SOUTH DUBLIN COUNTY COUNCIL'S PLANNING AUTHORITY'S REPORT TO AN BORD
PLEANALA ON APPLICATION FOR

SUBSTITUTE CONSENT UNDER SECTION 261A

AT BEHAN'S QUARRY WINDMILL HILL, RATHCOOLE

Date of Report: 18th August 2021

Drawing file: 03 - Substitute Consent Drawings / 310461 - 02 - Site Location - Local - 2500 A1.pdf

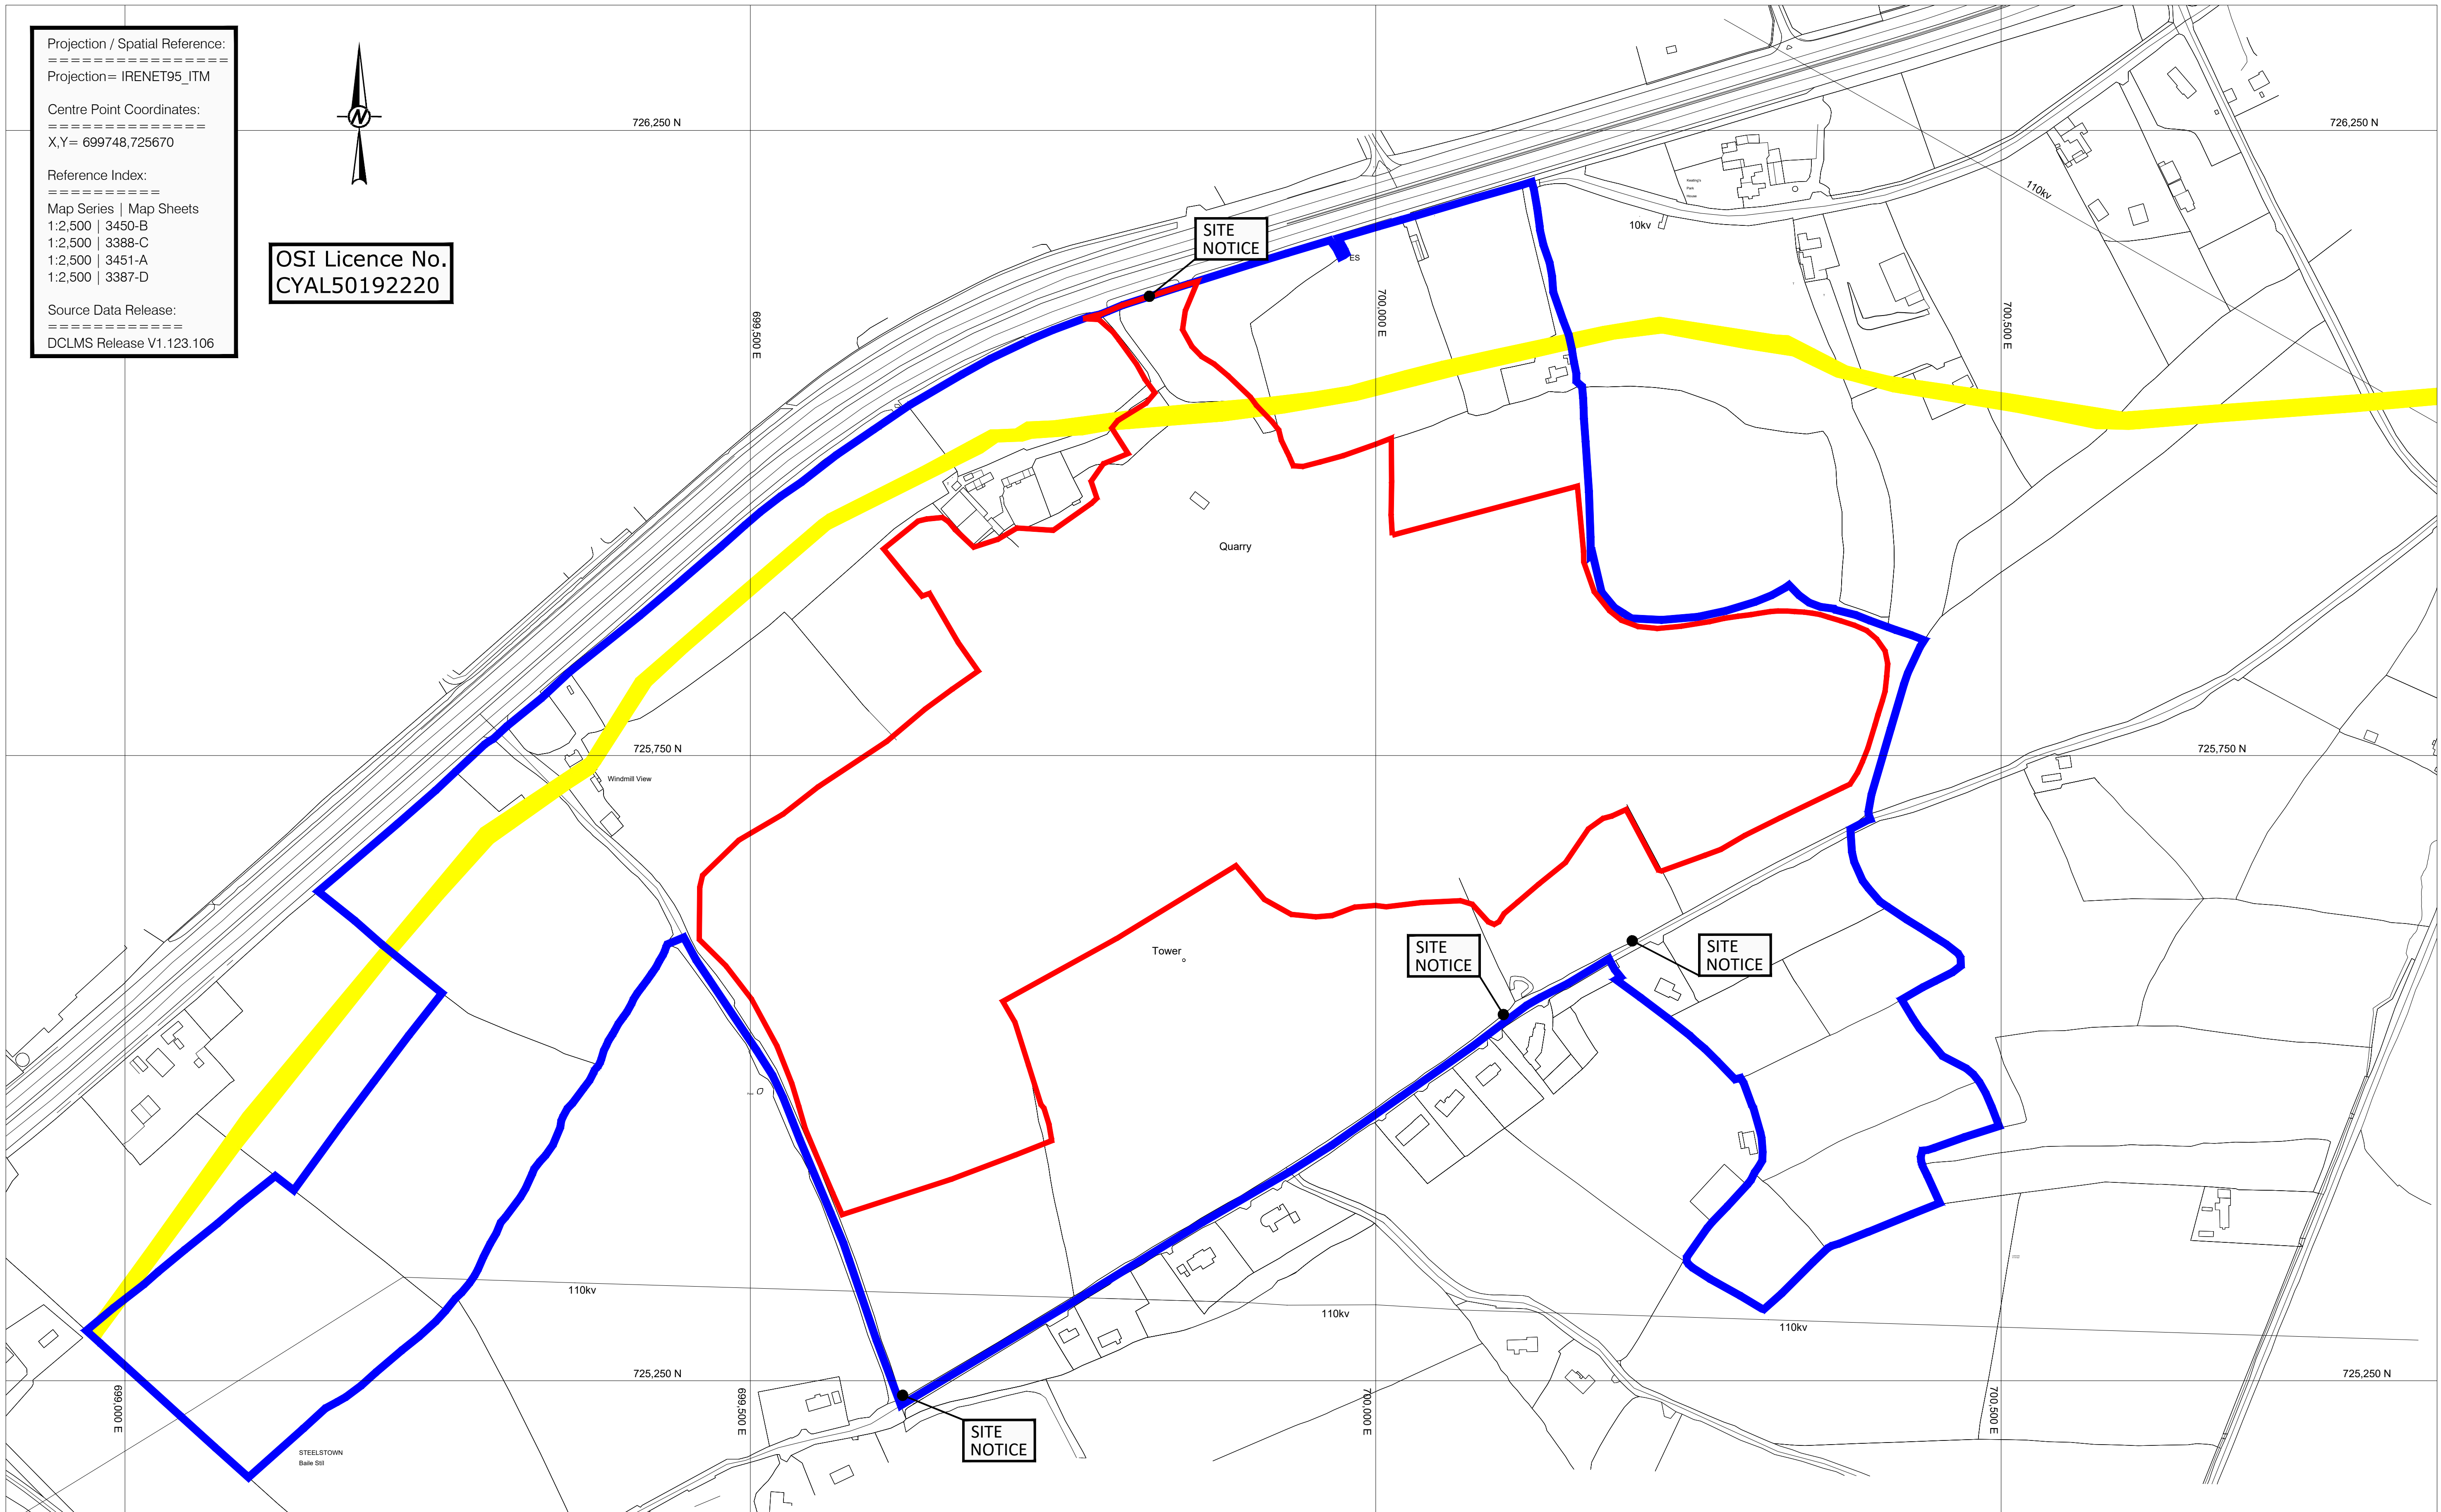
- 4.1 The Planning Authority notes the red line and blue lines as delineated on Site Location Map Project No. 20137776 Drawing No. 02 and would like to draw the Board's attention to works that may be carried out on lands outside of the red line and within the blue line to the north-west of the site. Refer land circled yellow, Figure 4.1.

9.2.1 Works that may have taken place outside of the application red line. Works have continued unabated since the submission of the application(s). ABP should seek further clarity to establish the full extent the retrospective development.

Drawing file: 03 - Substitute Consent Drawings / 310461 - 22 - Water Recycling Unit - 150 A3.pdf

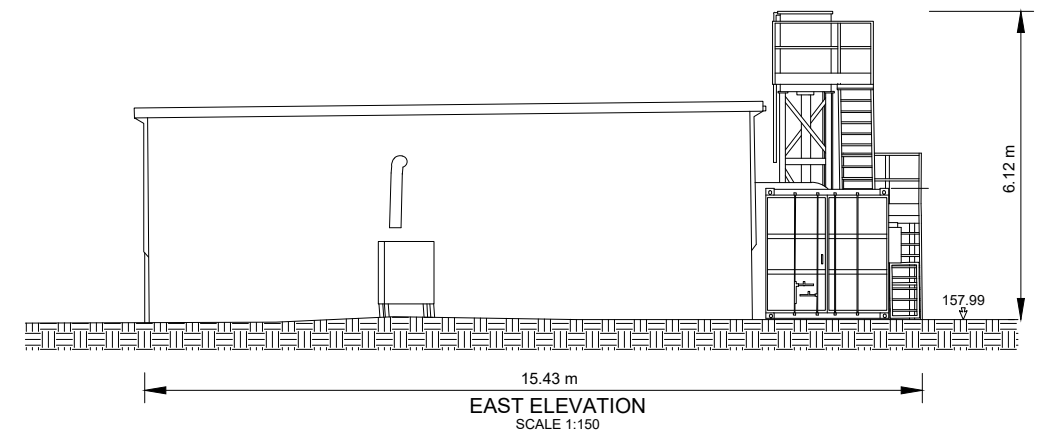
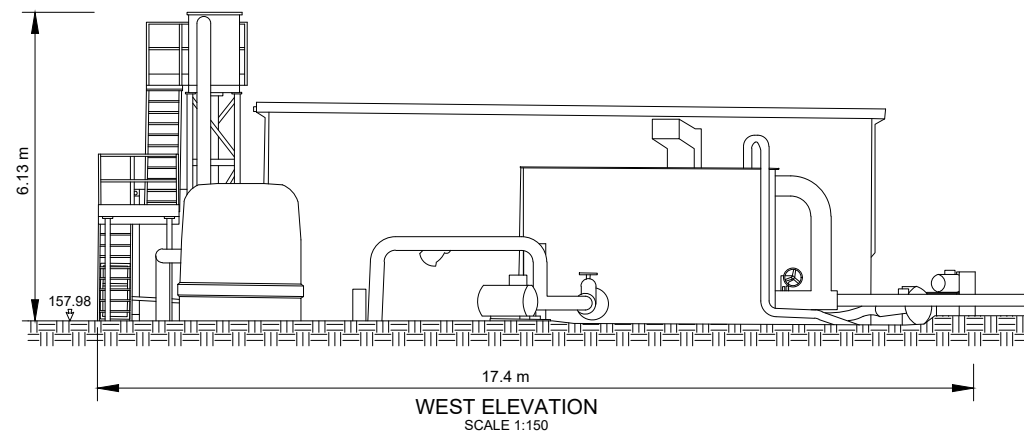
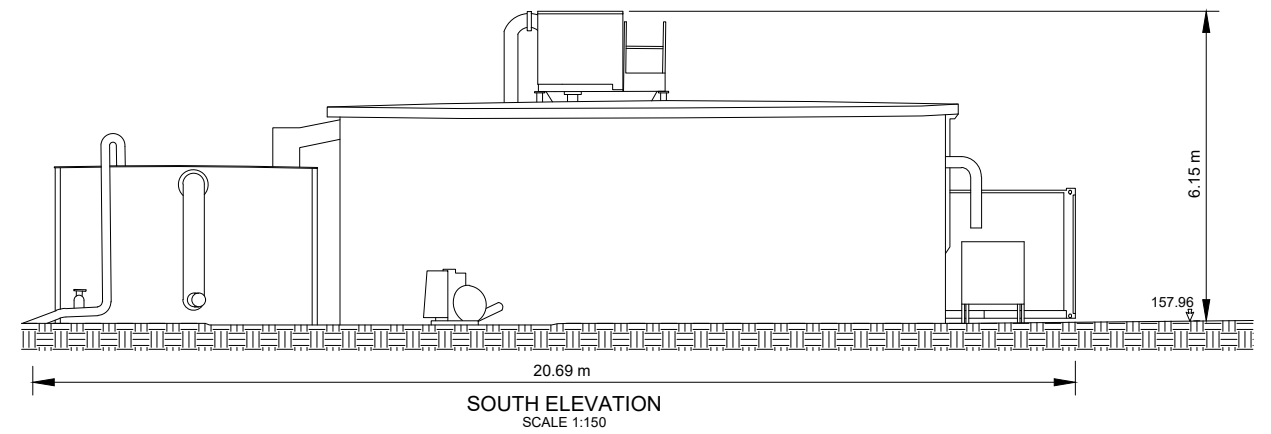
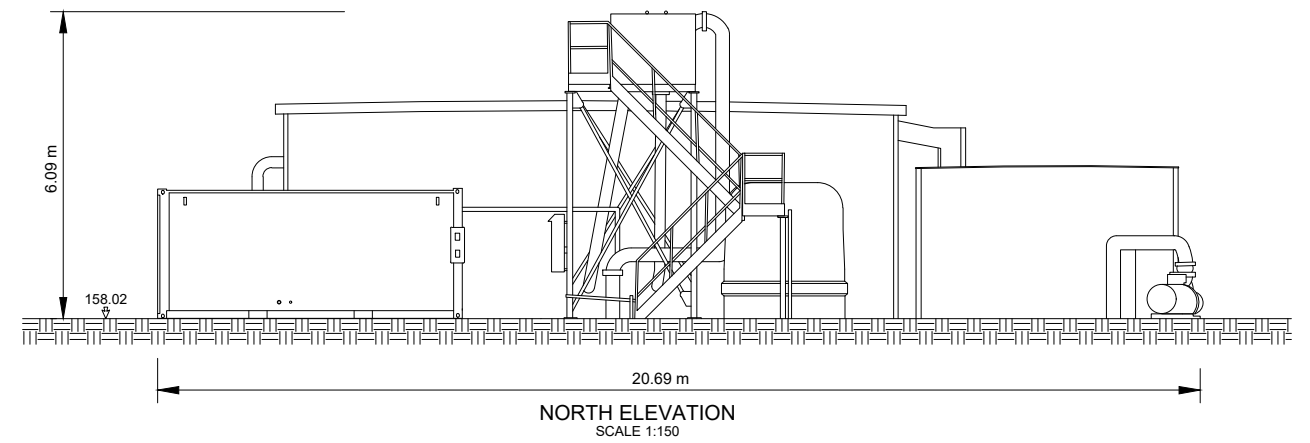
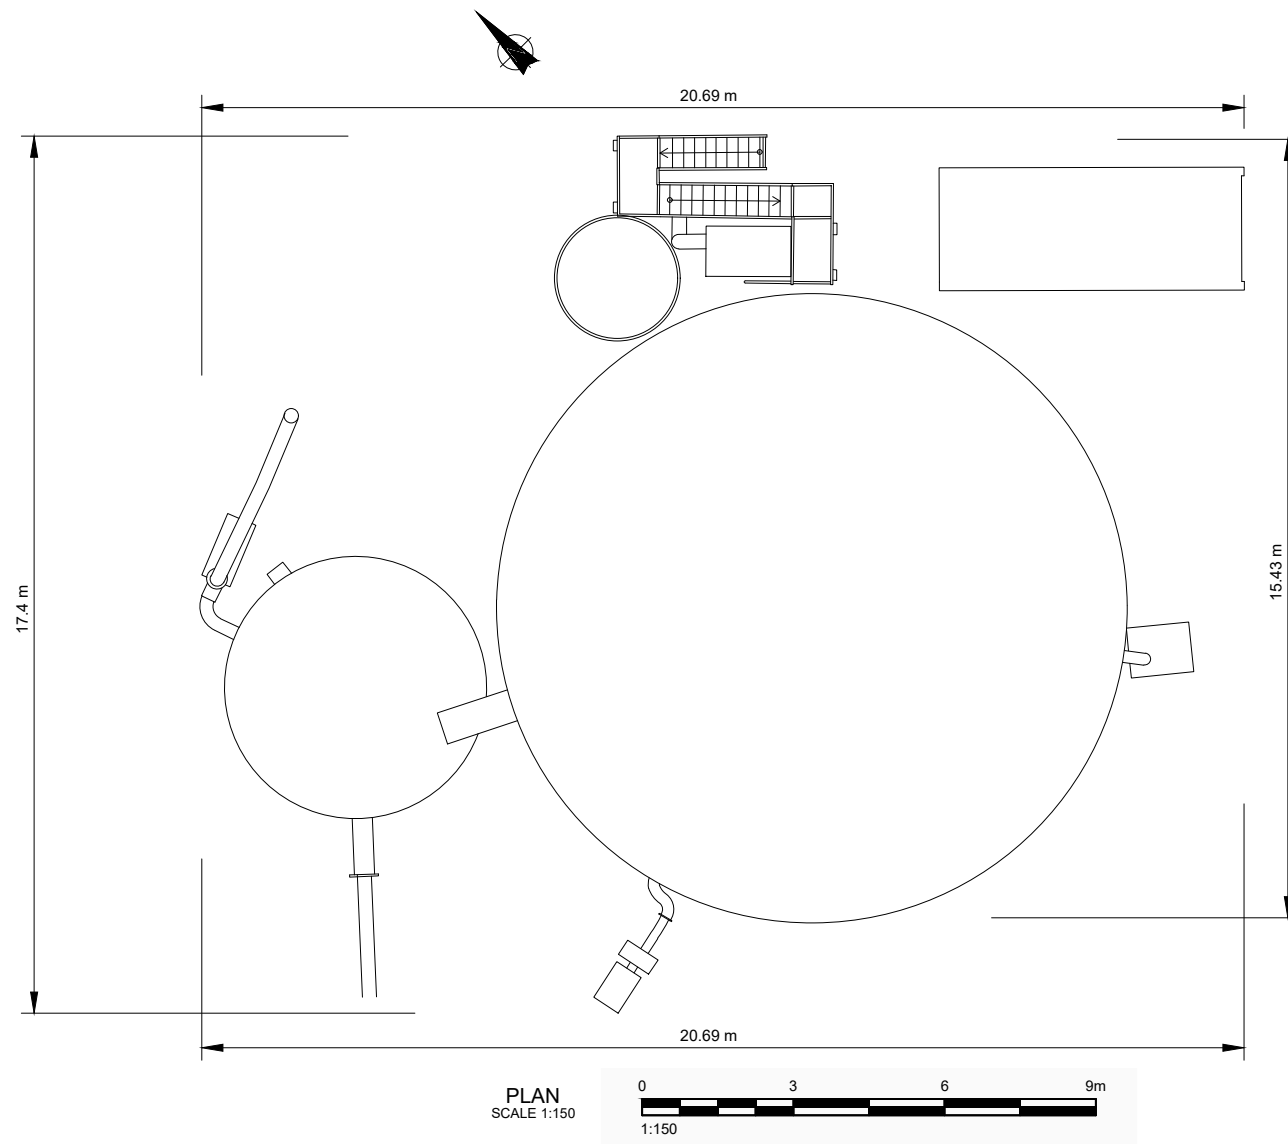
- i. 2 x office buildings,
- ii. 4 x portacabins,
- iii. 4 x containers,
- iv. 2 x storage/maintenance sheds,
- v. a storage/drying shed,
- vi. water recycling unit and silt press,
- vii. a concrete plant and washing, crushing, screening and bagging plants

The Planning Authority recommend that ABP seek clarification on these works/development and request the applicant, by way of additional information request to submit all relevant planning permissions for the above development and/or a proposal for regularising the development, if necessary.

- c. 4 x containers,
- d. 2 x storage/maintenance sheds,
- e. a storage/drying shed,
- f. water recycling unit and silt press,
- g. a concrete plant and washing, crushing, screening and bagging plants

The Planning Authority recommend that additional information should be requested to establish the status of these works/development and seek the applicant, to submit all relevant planning permissions for the above development and/or a proposal for regularising the development, if necessary.
